From: Cornerstone [REDACTED]
Sent: 24 October 2018 22:22
To: Charlotte Bodin
Cc: 'Anthony Sullivan'
Subject: 181024 AH-CB FW: 181016 AH-CB FW: Further Information Required on Your Ref: PP-07271945 Our Ref: FP/212/18/HH
Attachments: 09 Block Plan proposed.pdf
Follow Up Flag: Follow up
Flag Status: Flagged

Ref: PP-07271945 Our Ref: FP/212/18/HH

40 Minton Road Felpham Bognor Regis

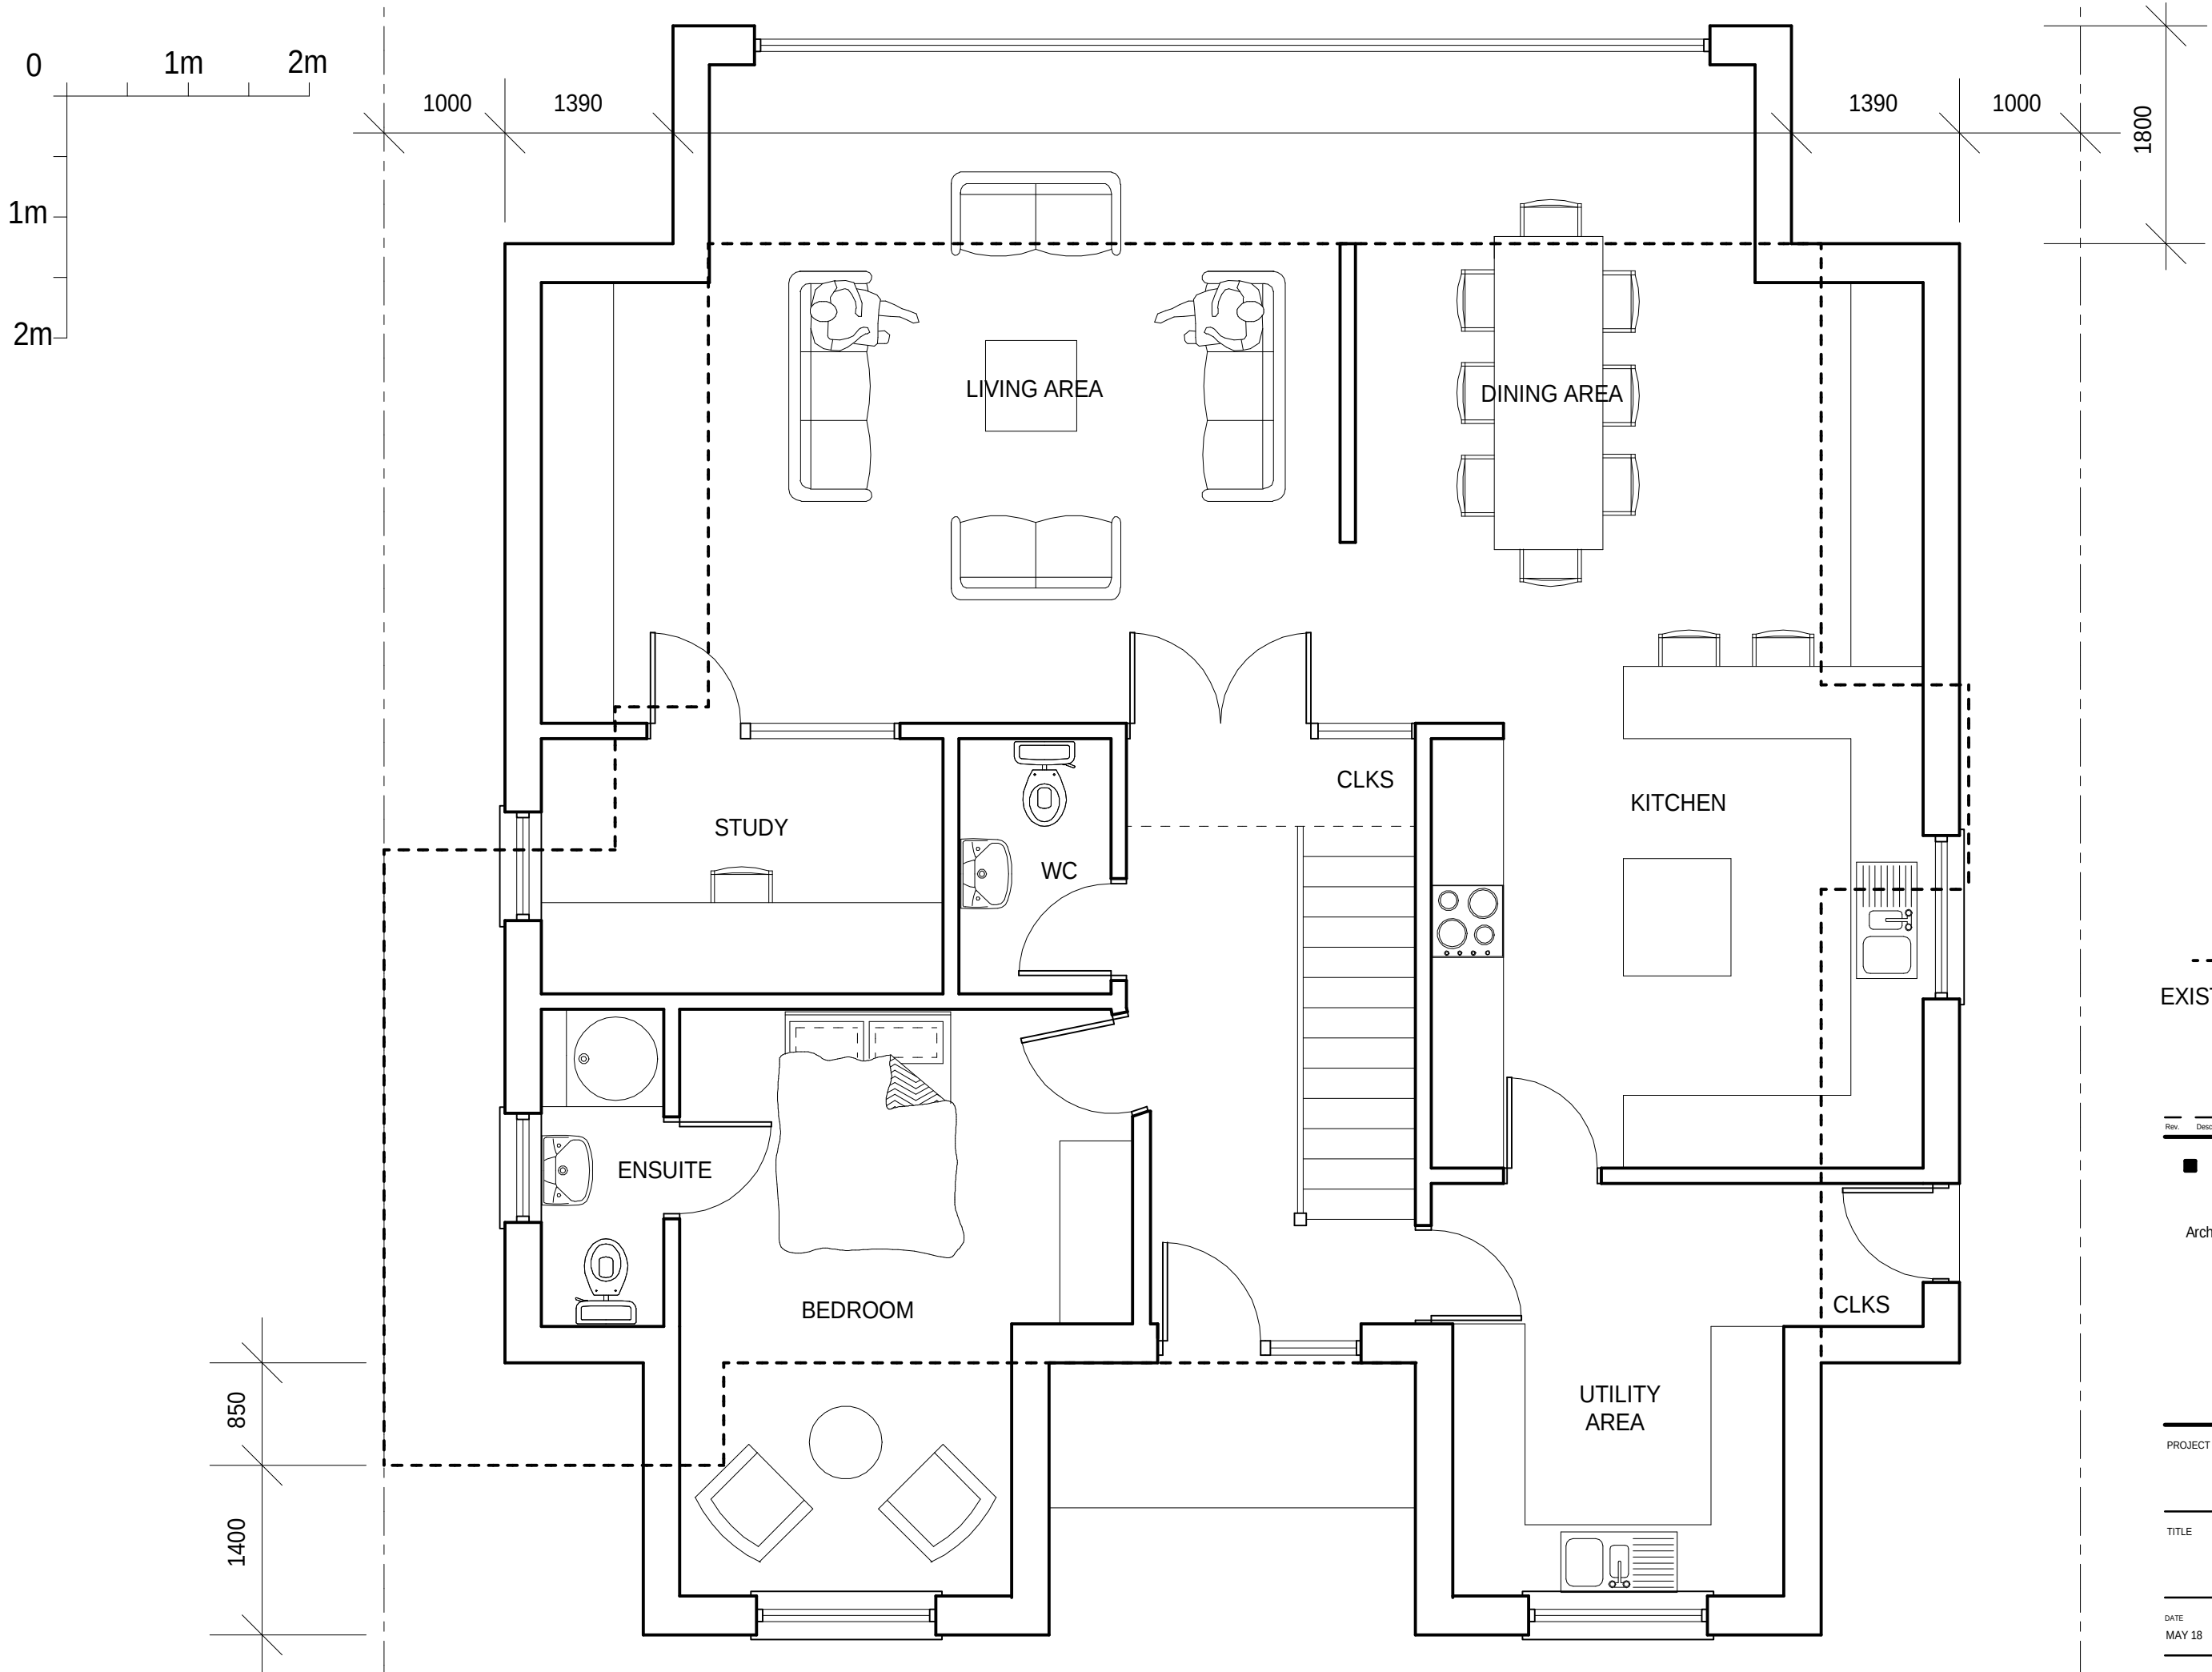
The proposed dimensions to the boundaries are clearly annotated on drawing 10.
